An
Bord
Pleanála

Inspector's Report ABP-310798-21

Proposed development of that portion of an electricity transmission interconnector (Celtic Interconnector) to be constructed onshore in Ireland to the mean high water mark, including a connection to the Irish National Grid, an electricity converter station and all associated and ancillary works.

EirGrid PLC

Drawing Number
229100428-MMD-00-XX-DR-E-4117

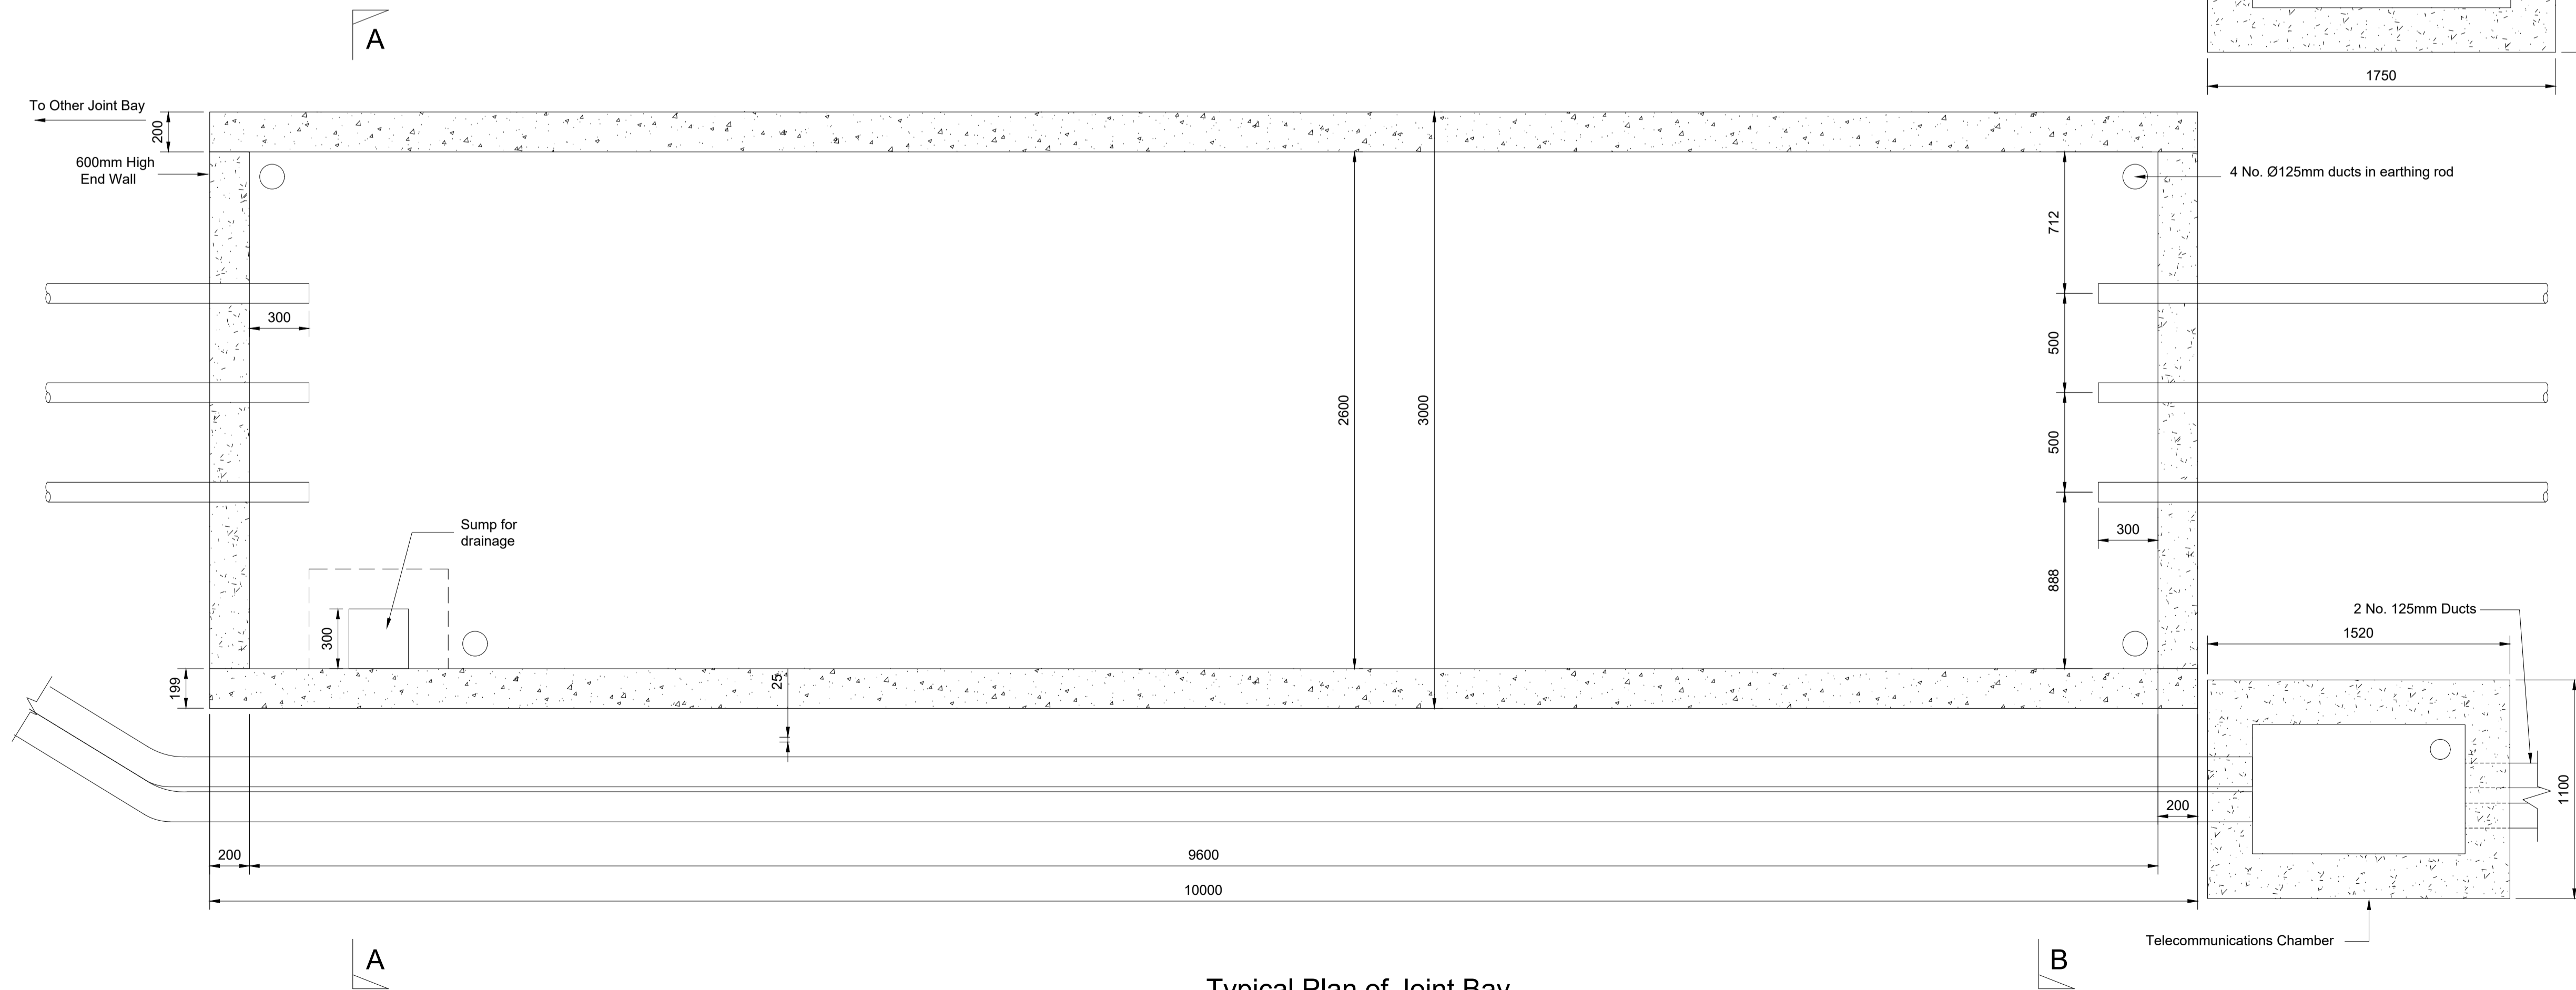
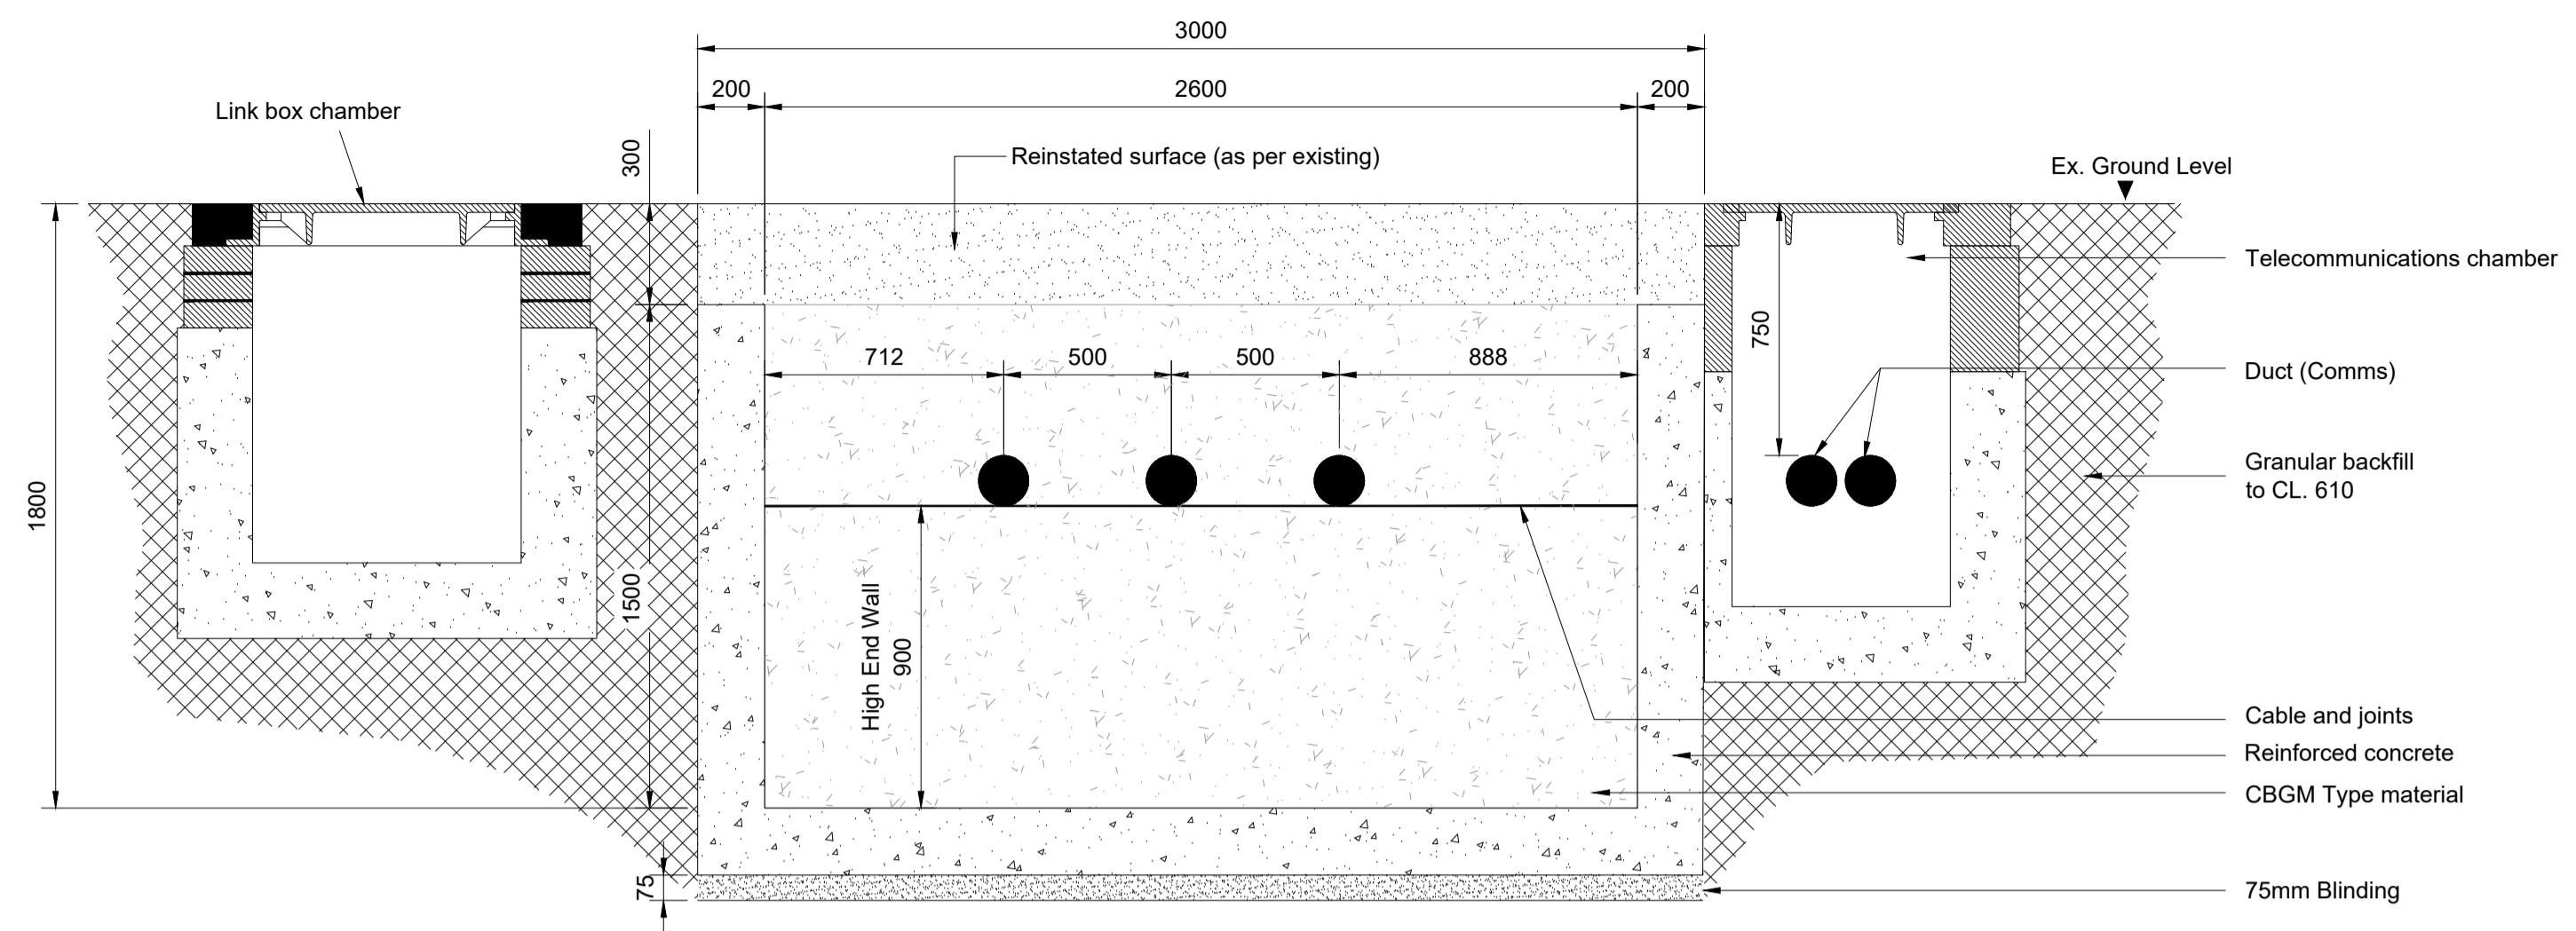
- Concern is raised in relation to the width of jointing bays on narrower local roads.
- Potential for works at the Ballyadam Converter Station site having an impact on the route corridor of the N25.
- Specific supporting policy for the project is included within the Draft Cork County Development Plan 2022-2028.
- Zoning at Landfall is identified as 'existing built up area'.
- Zoning at Ballyadam Converter Station is 'industry'.
- Principle of development is acceptable.
